From: Laura Gibbons <Laura.Gibbons@arun.gov.uk>
Sent: 14 February 2022 14:38
To: Planning.Responses <Planning.Responses@arun.gov.uk>
Cc: Michael Eastham <Michael.Eastham@arun.gov.uk>
Subject: RE: Planning Consultation on: BN/127/21/DOC

Comments Regarding Condition 3

Application No: BN/127/21/DOC

Site Address: Land At Angels Nursery Yapton Road Barnham PO22 0AY

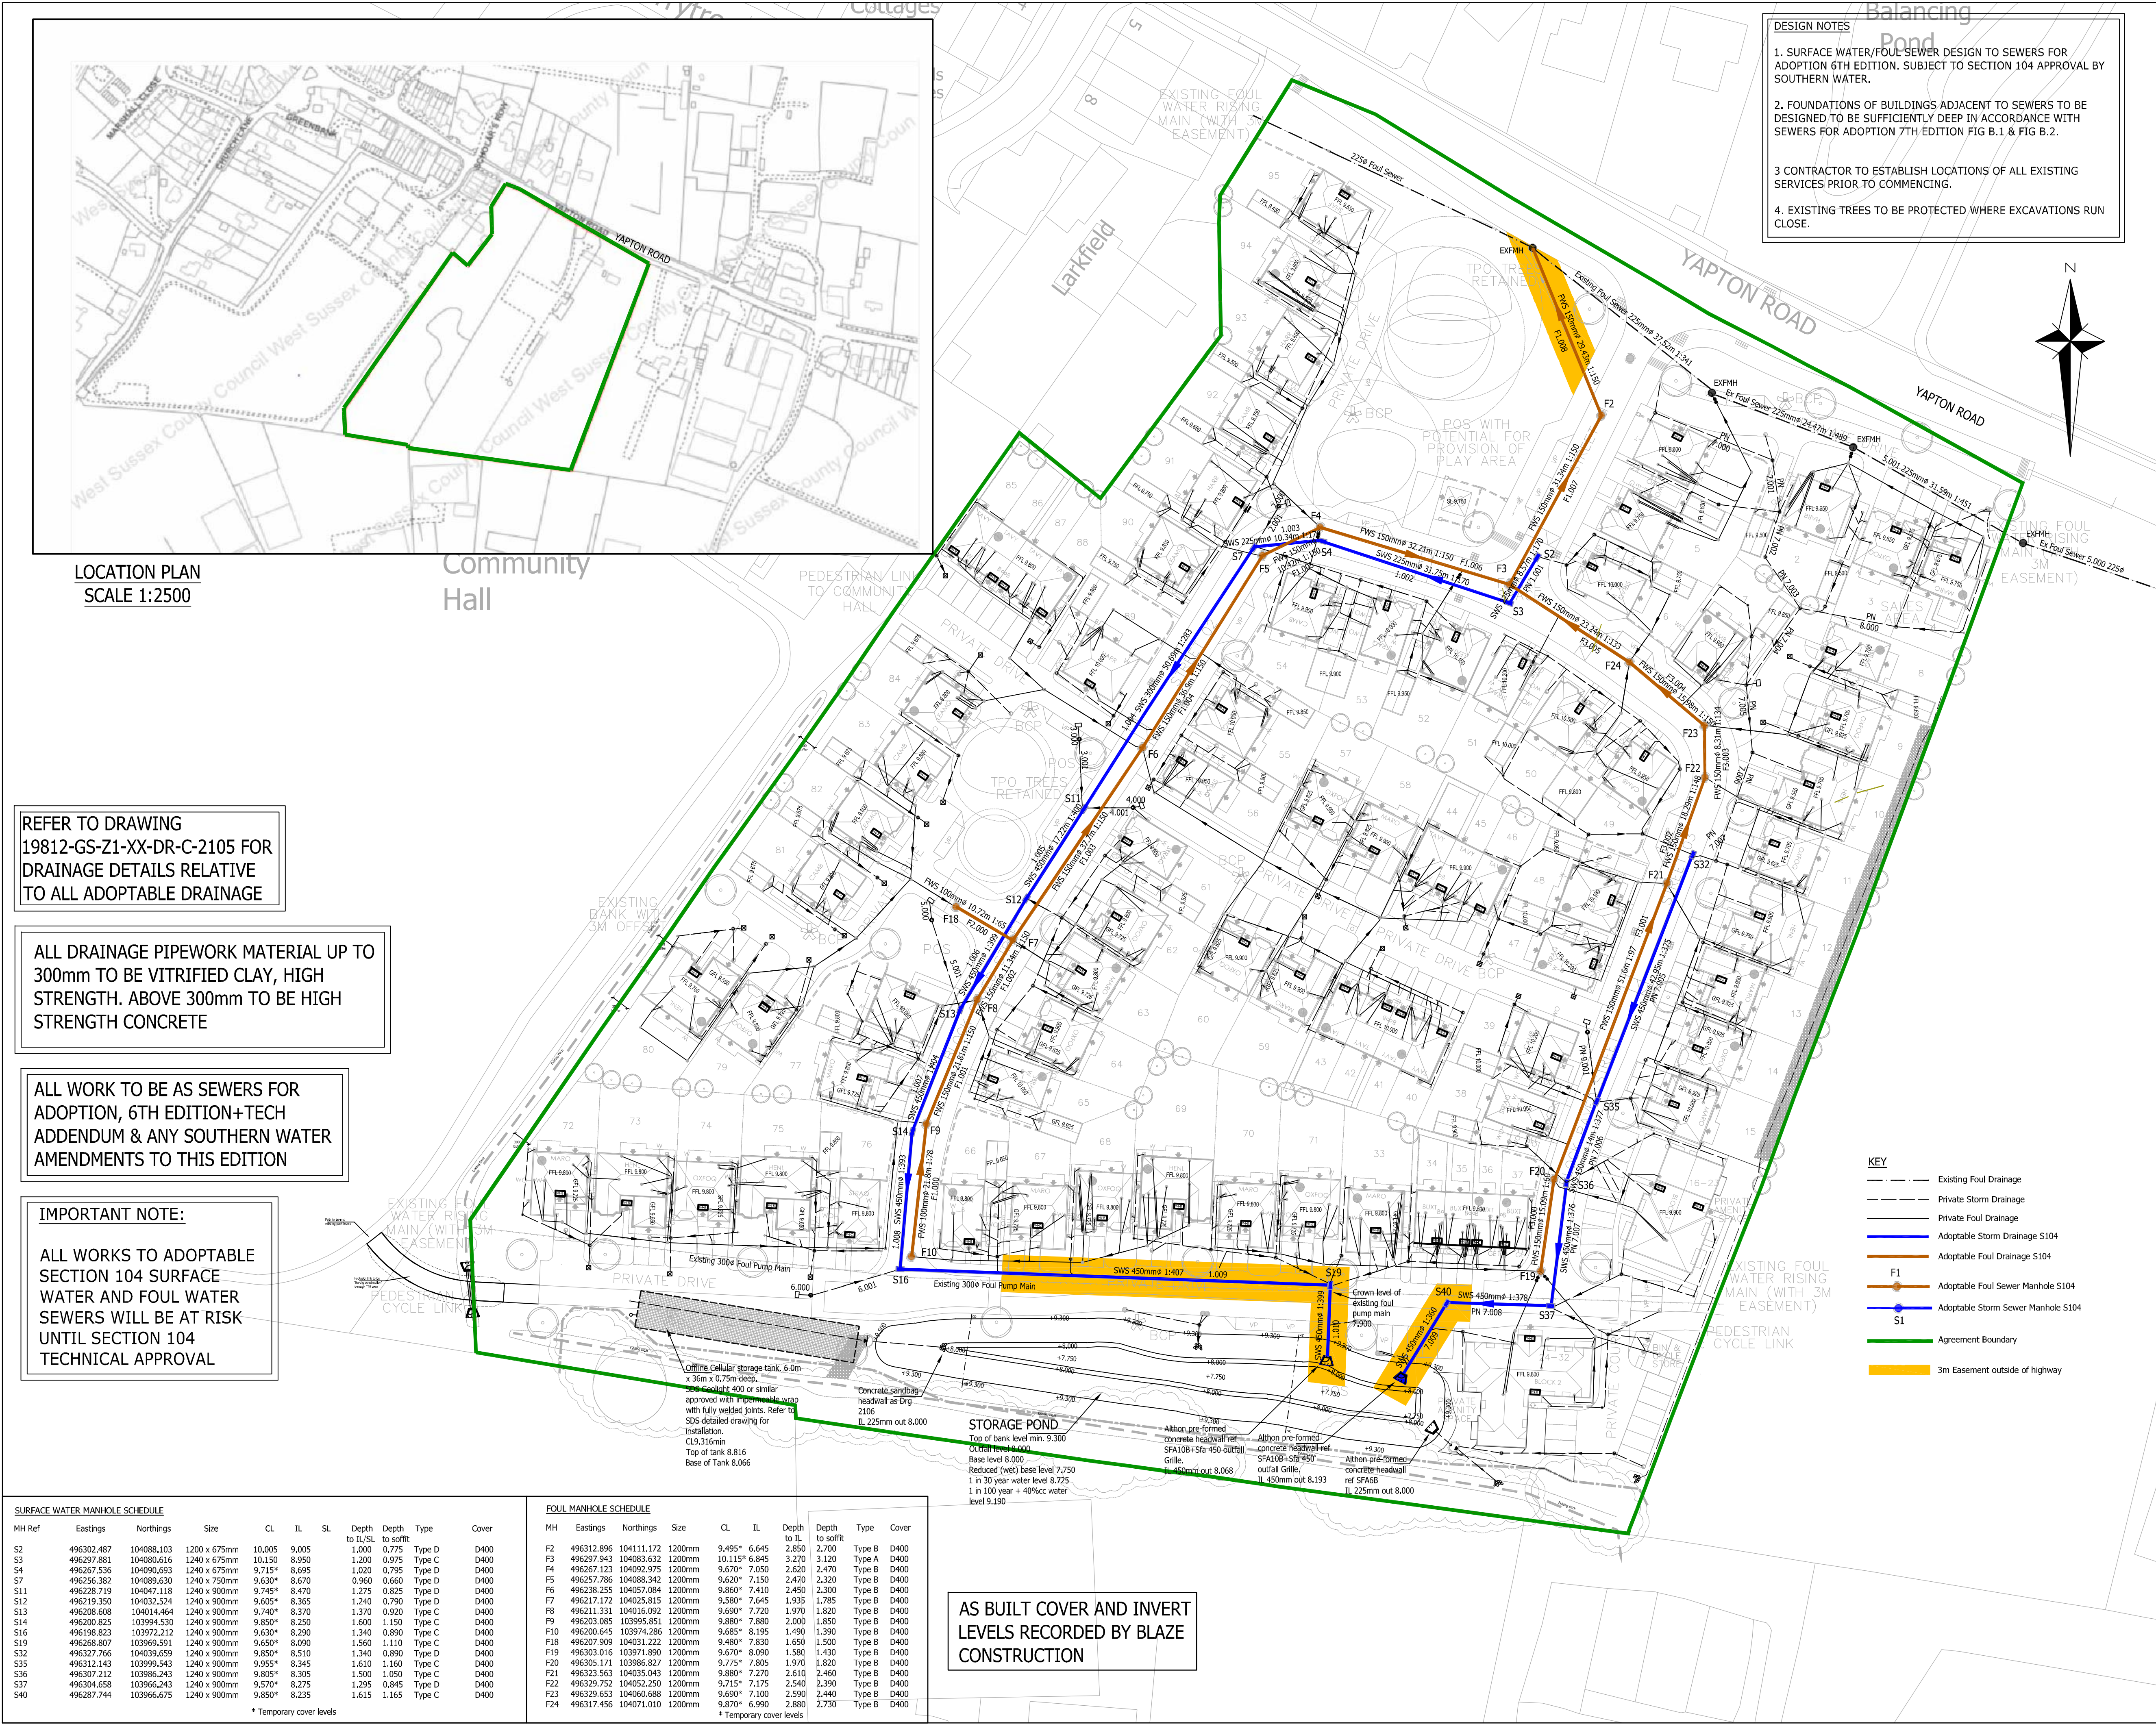
1. Please can the author of the verification report detail their independence and qualifications.
2. Please can the author of the verification report provide a clear statement regarding their view on the adequacy of the constructed surface water drainage.
3. Please provide fully detailed as built layouts.
4. The report should comment upon any discrepancies between as built survey and design.
5. Details of any remedial works as a result of CCTV survey should be included within the report.
6. We note that the land drainage consent works have not been signed off as the district engineer has not been invited to inspect the works.
7. We also note that the applicant does not have land drainage consent approval for the culvert to facilitate the path crossing over the ditch, we hence expect that this crossing has not been constructed.
